Your Reference: SSD 5175-2012
Our Reference: SYD12/01182
Contact: Dianne Rees
Telephone: 8849 2237

**SYDNEY
REGIONAL
DEVELOPMENT
ADVISORY
COMMITTEE**

**CONCEPT PROPOSAL AND STAGE 1 EARLY WORKS FOR EASTERN CREEK
BUSINESS HUB, ROOTY HILL ROAD SOUTH, ROOTY HILL
SSD 5175-2012**

Figure 10: Proposed Intersection of Rooty Hill Road South with Primary Site Access

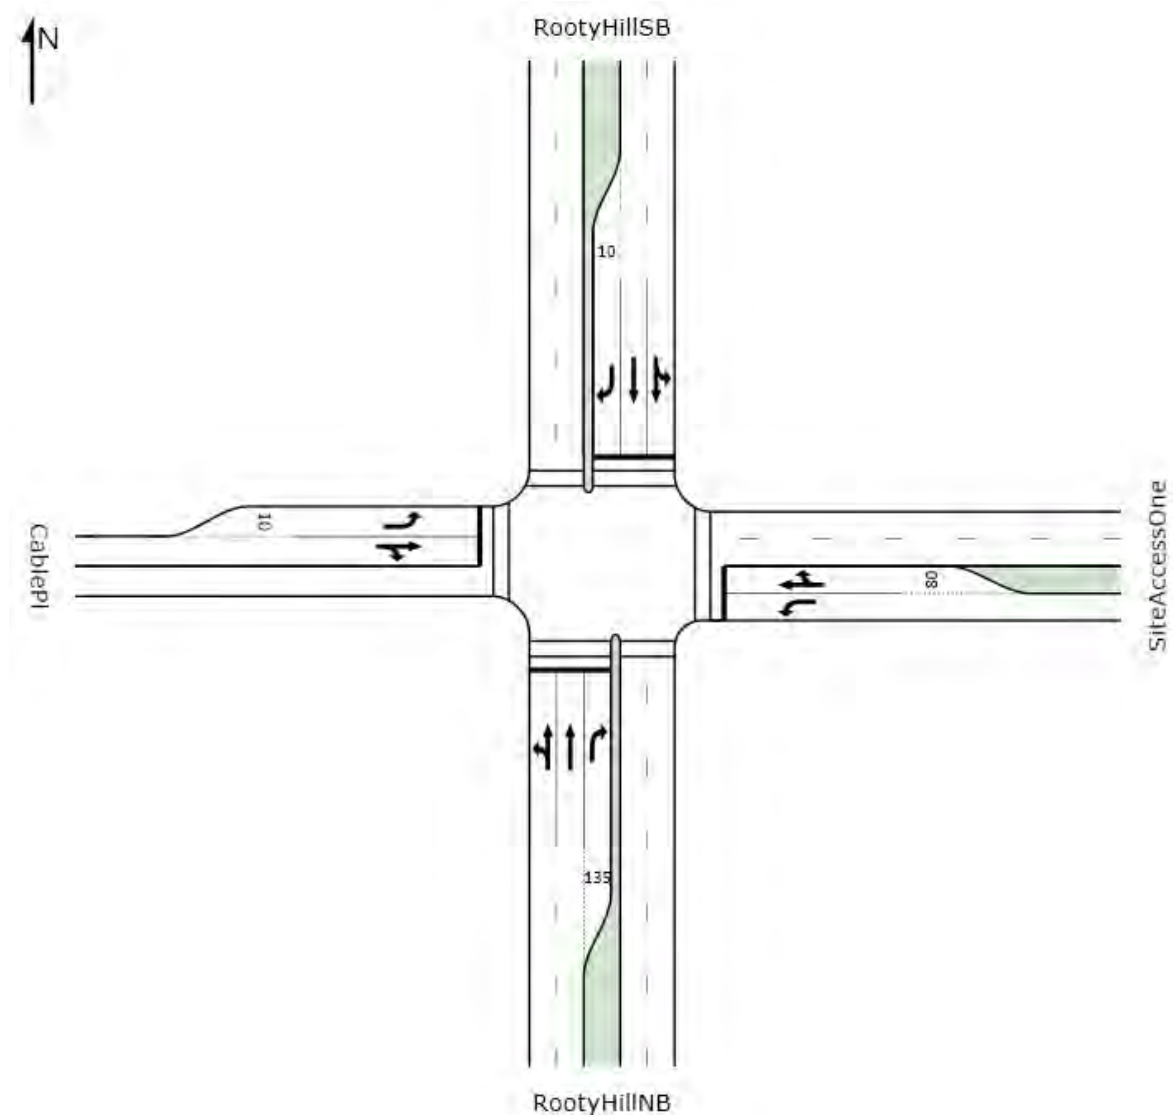
RMS does not support the location of the proposed access to the development being located opposite Cable Place, due to the existing geometry of the intersection.

As an alternative, the Cawarra Street/Rooty Hill Road South or the Penfold Street/Rooty Hill Road South intersections would be more suitable locations for an access to the development as a fourth leg to the intersection.

The approval of traffic signal installation at either of these locations will be strictly dependent on the warrants for signalisation being met. The warrants for signalisation are contained in Section 2 – Warrants – Traffic Signal Design Guide.

Figure 11: Proposed Signalised Intersection of Rooty Hill Road South with Great Western Highway

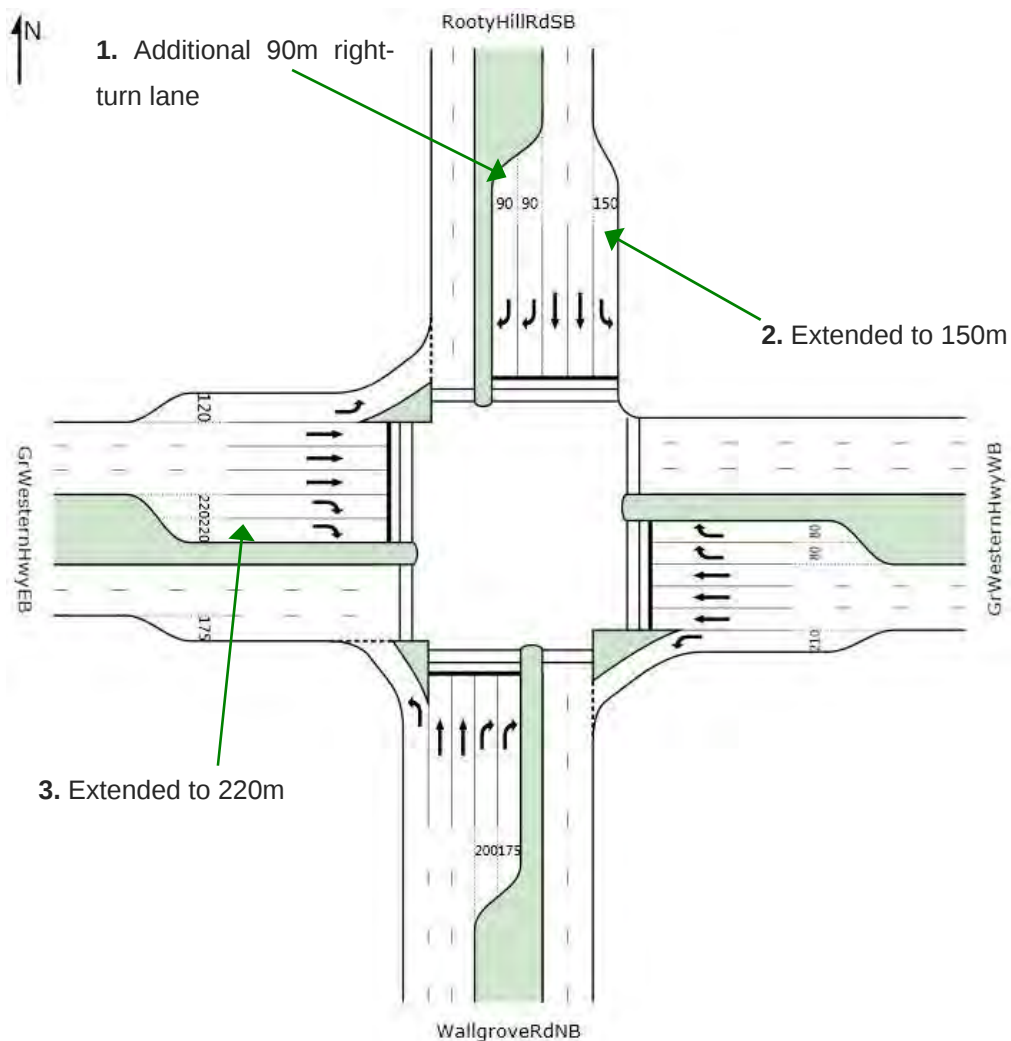
The traffic modelling for the Great Western Highway/Rooty Hill Road South and the Great Western Highway/M7 ramps intersections should be revised using UK Transyt 14, using traffic stream methods i.e. lane by lane techniques. Sidra is not suitable as it models intersections in isolation and cannot capture queue spill back issues at adjoining intersections. The revised modelling should be carried out for the current and future traffic conditions and should be consistent with the Sidra modelling (projected traffic volumes for 2022 with the development and without the development). The submitted distribution analysis indicates that 75% of traffic generated by the development, will impact on these intersections.
